Your ref: 3/2019/0477
Our ref: DC/19/2765
Date: 30-JUL-19

Location: Moorgate Farm, Kenyon Lane, Langho, BB6 8AN

Proposal: Change of use of agricultural land for the siting of six camping pods as an extension to the existing camping development at the site

Proposed Site Plan - 1:500

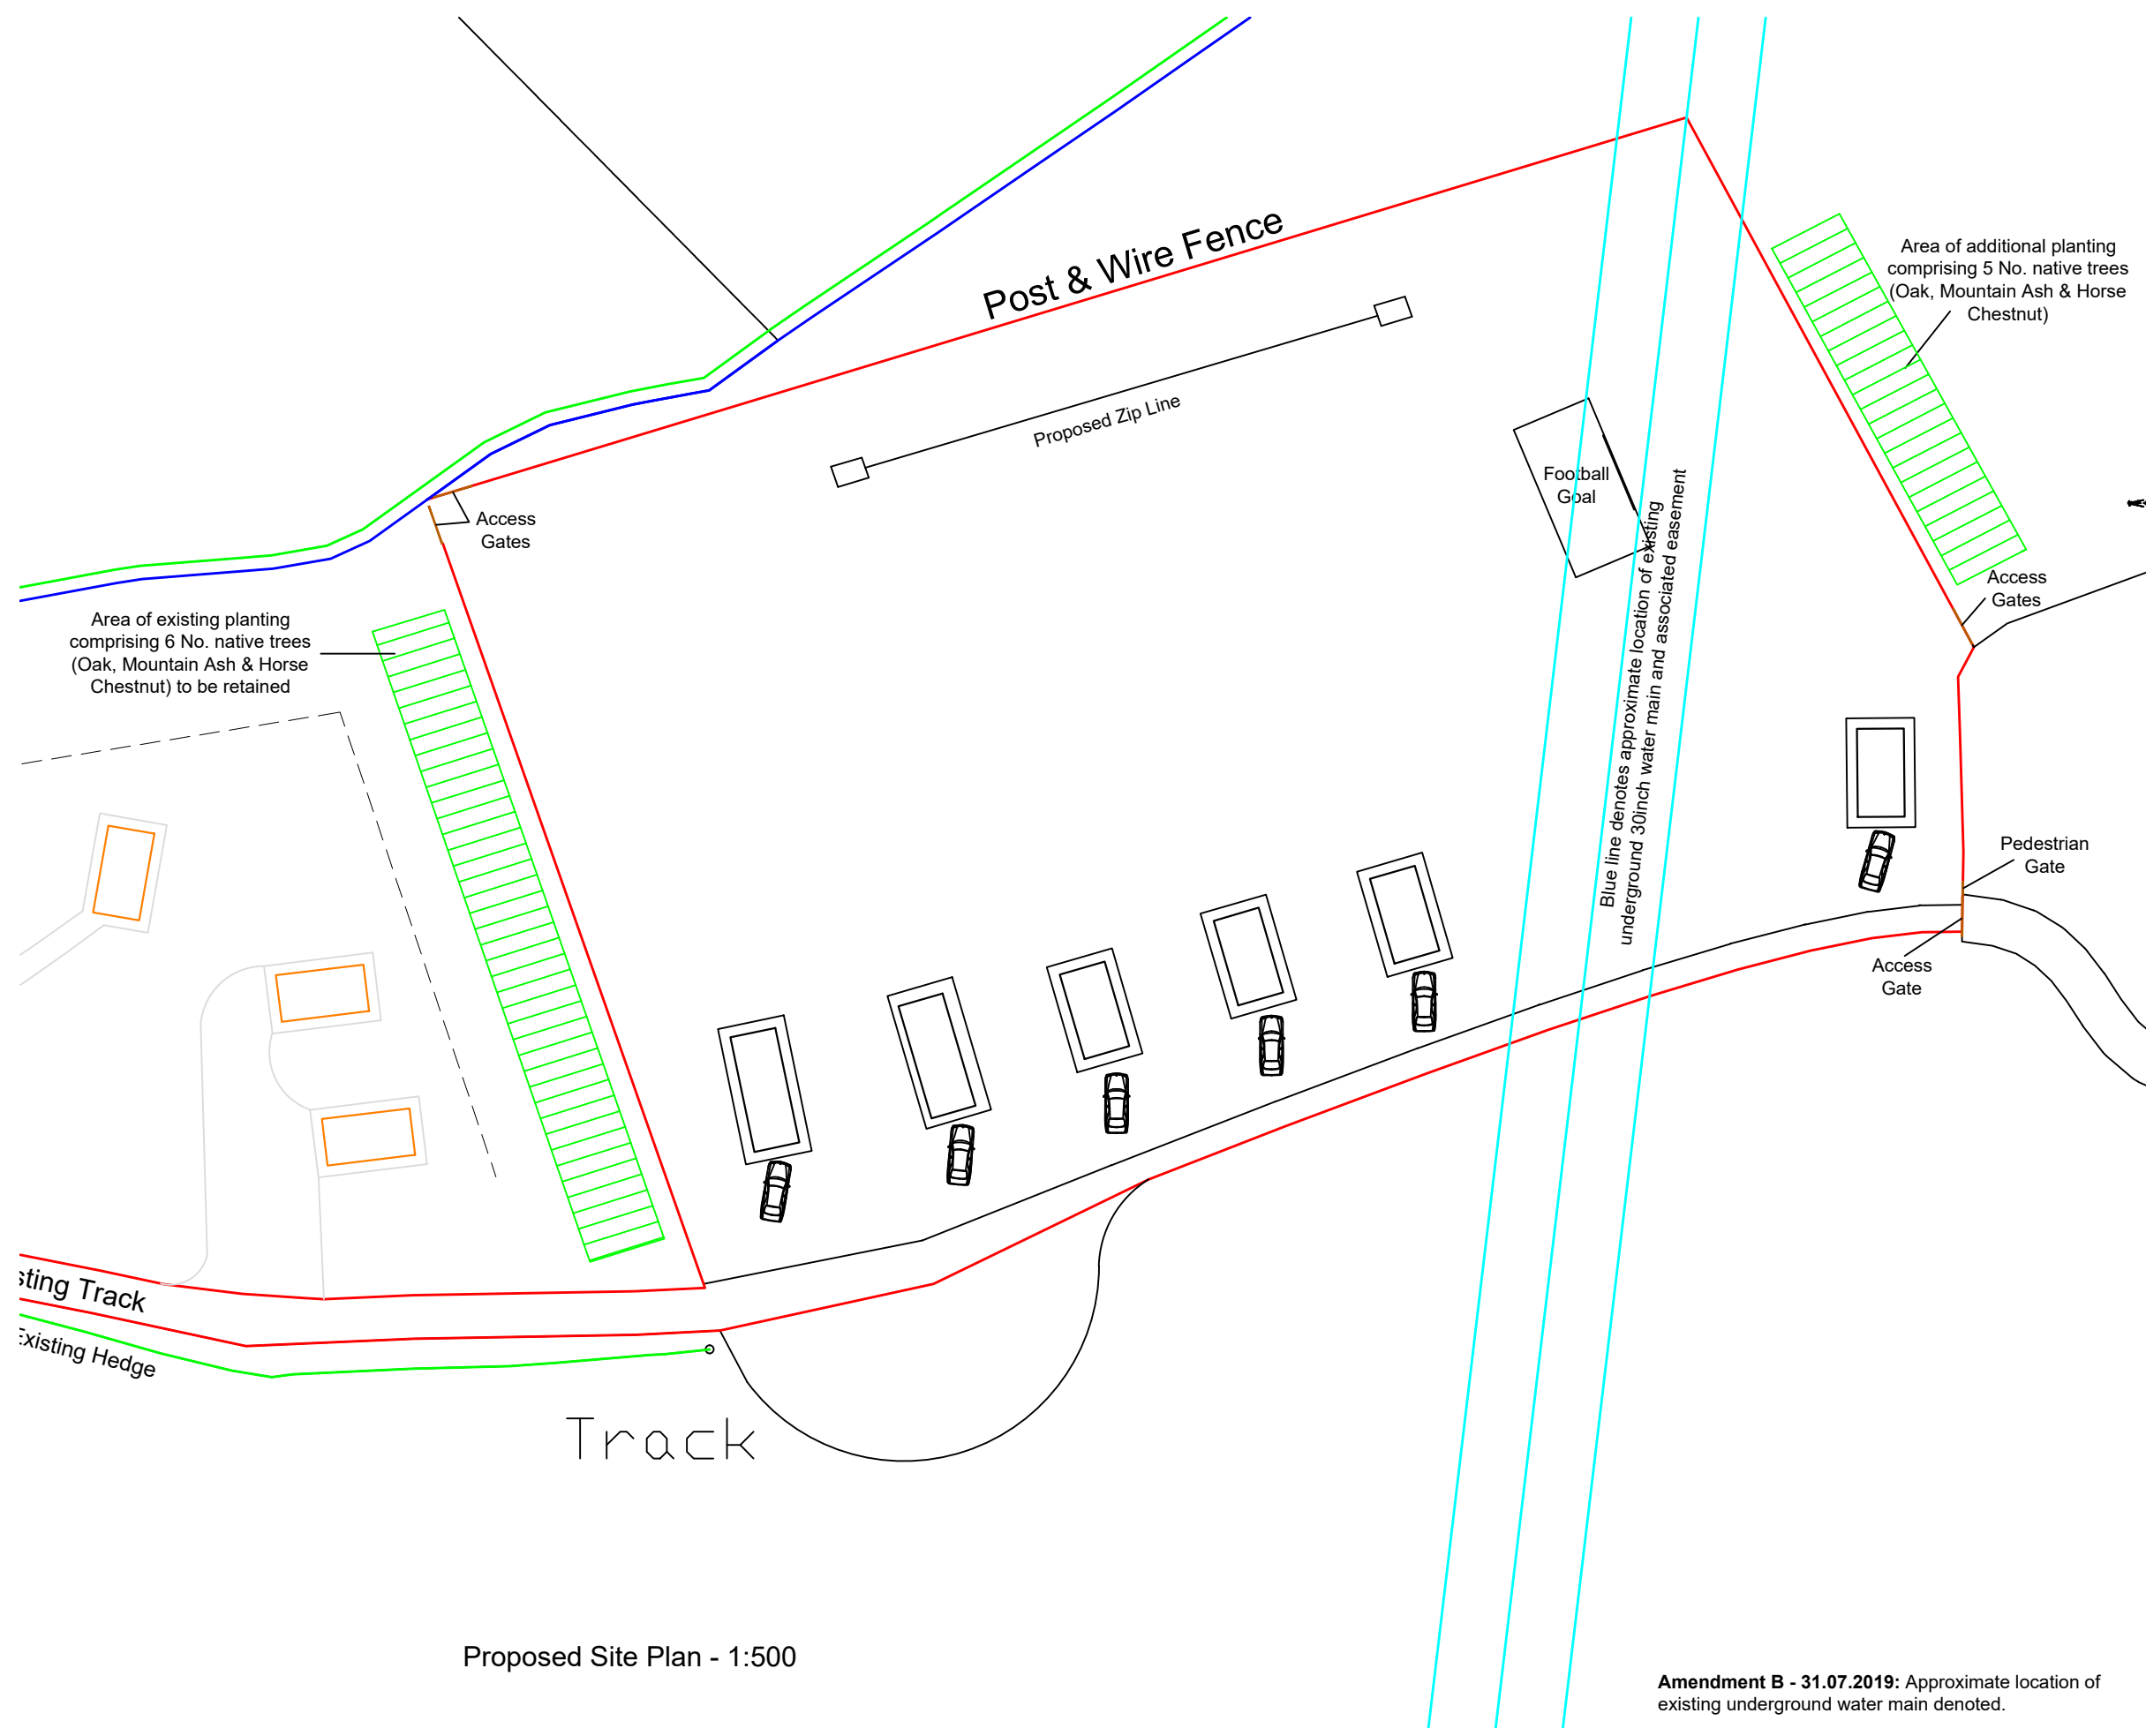
Following our review of the applicant's 'Proposed Detail Site Plan' Drawing No. Bre/096/2673/02, Dated 20.05.19 it appears the pods will be directly above United Utilities' water main and associated easement. Our current position is that this is not acceptable to United Utilities and therefore we must OBJECT to this proposal.

Title: Proposed Detail Site Plan

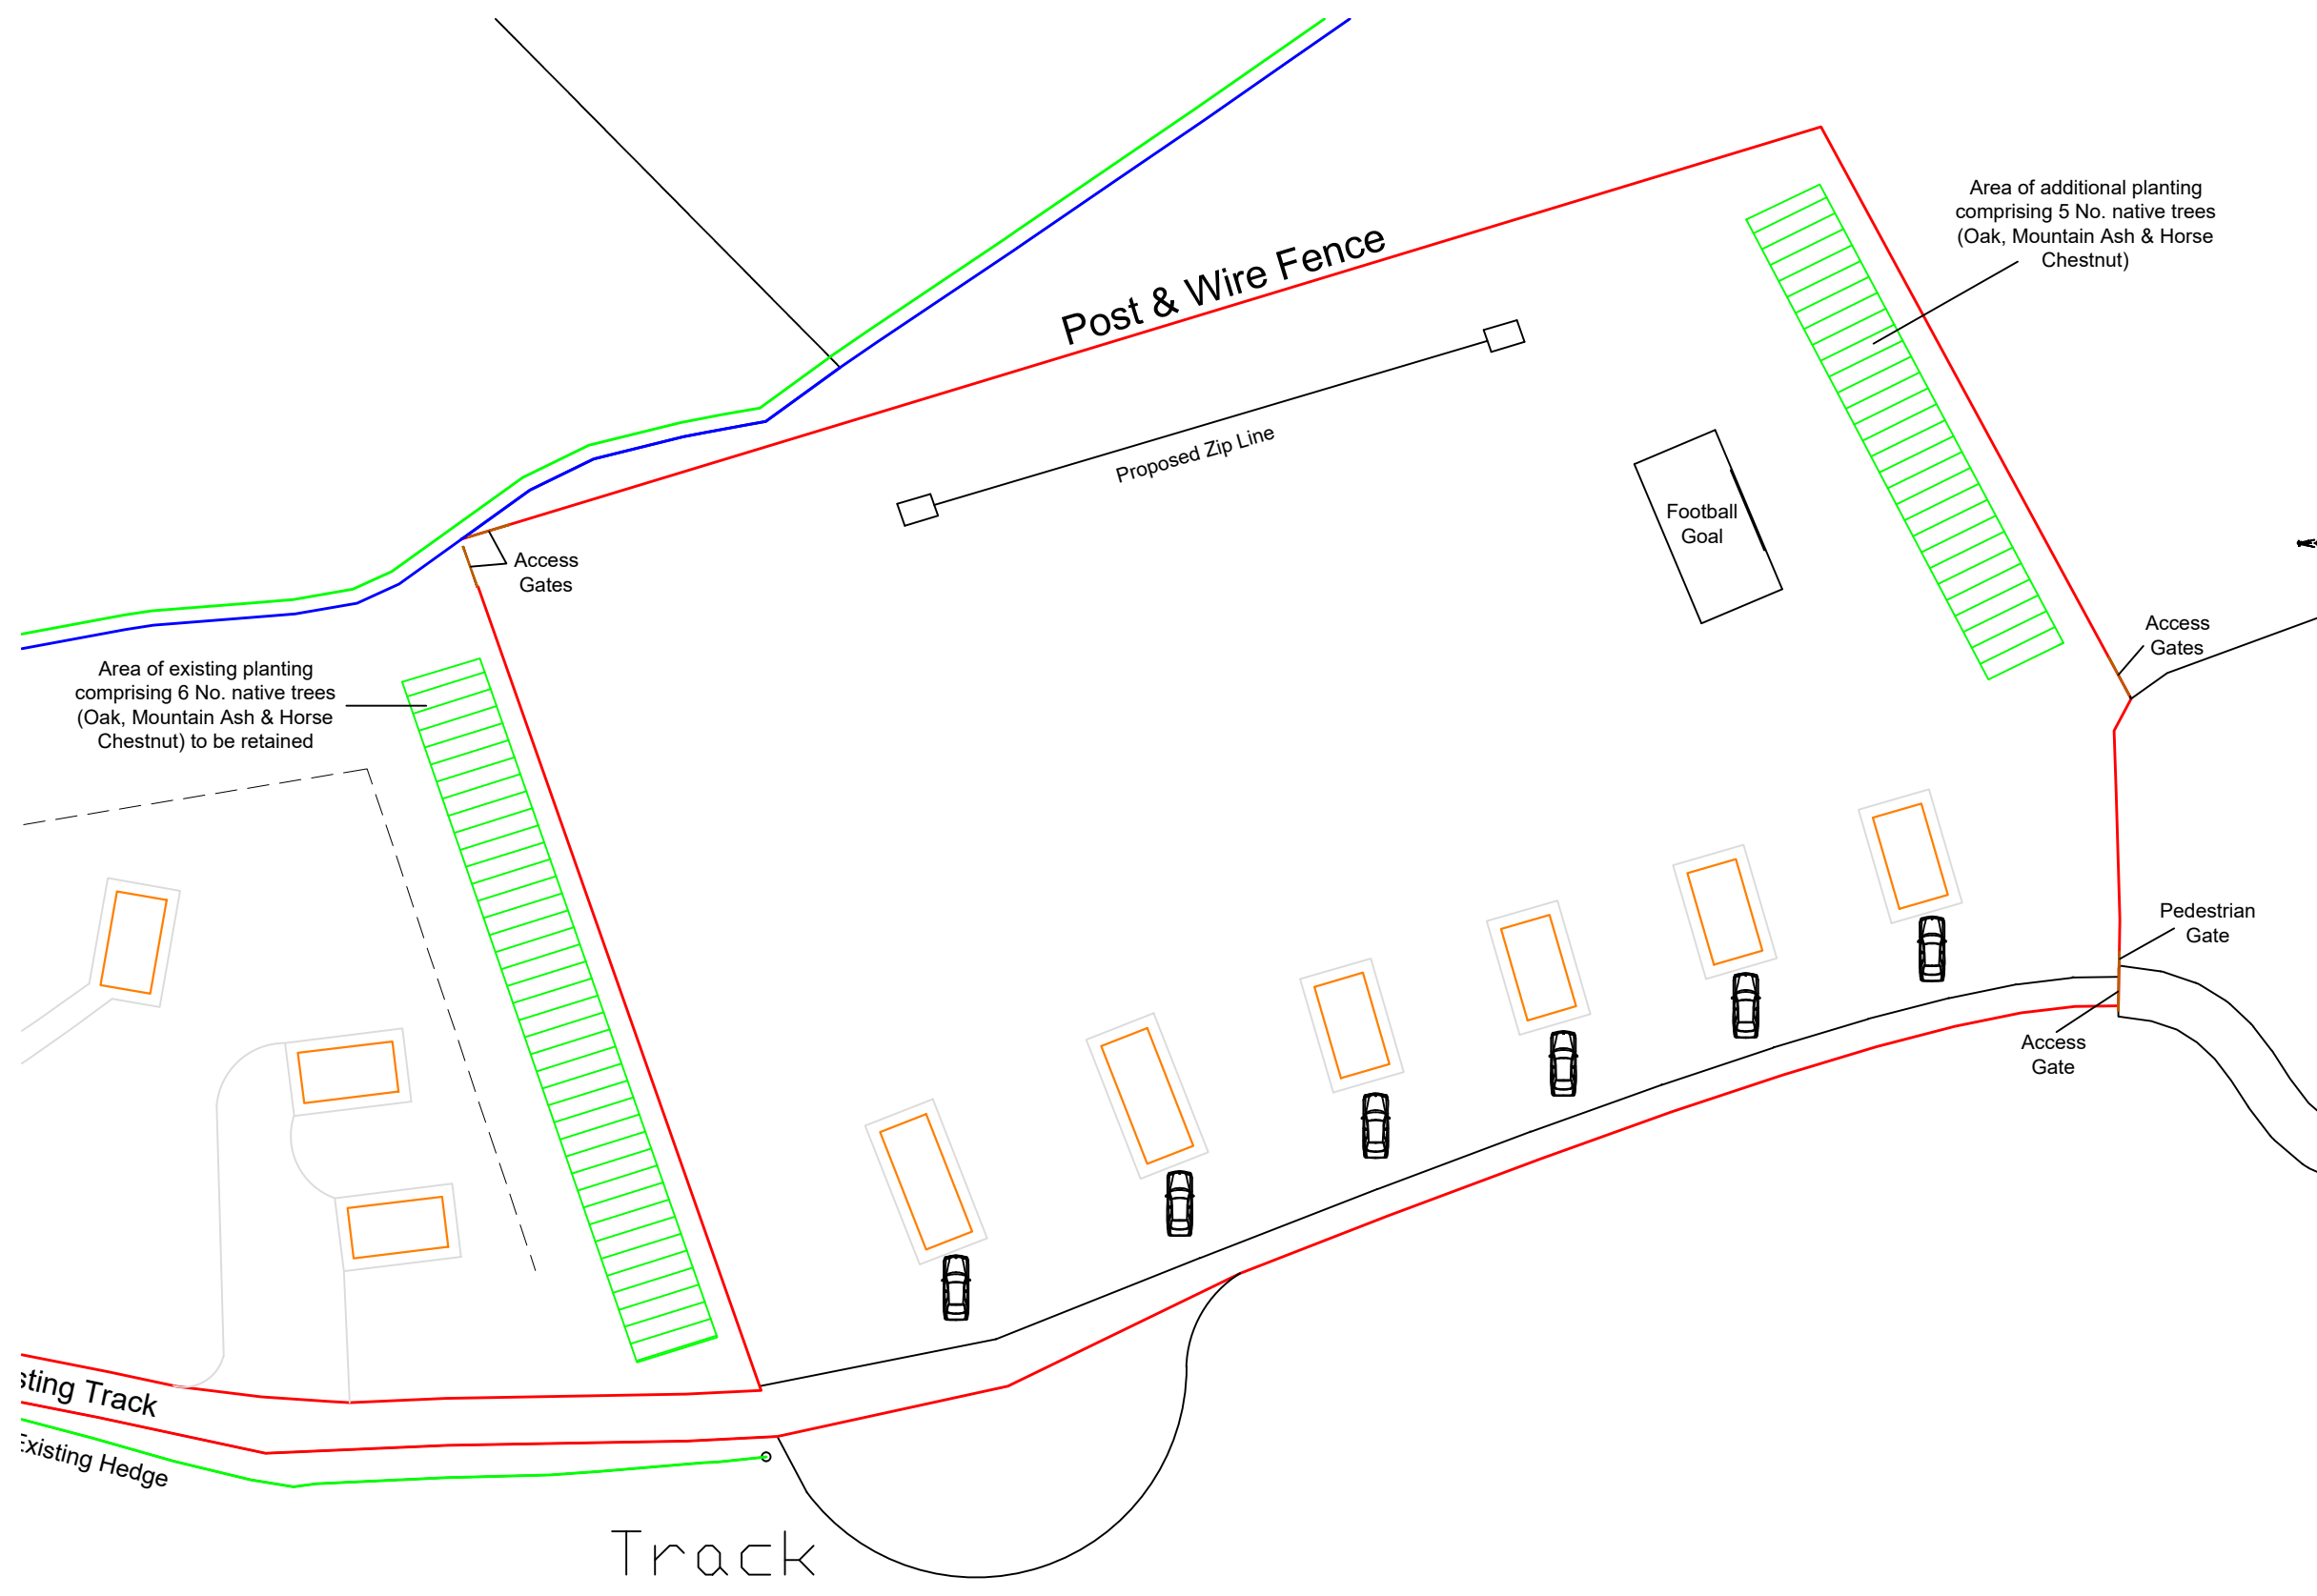
We also note the area of additional tree planting in the vicinity of the water main. Our 'Standard Conditions' document includes details of trees and shrubbery suitable for planting in the vicinity of a water main. The applicant should consult this document to ensure their landscaping proposals meet with the advice provided in the document. We also recommend the use of root barriers to afford additional protection to the water main.

To overcome this objection, the applicant should relocate their proposed camping pods and associated parking spaces, providing a 10 metre access strip, 5 metres either side of the centre line of the pipe.
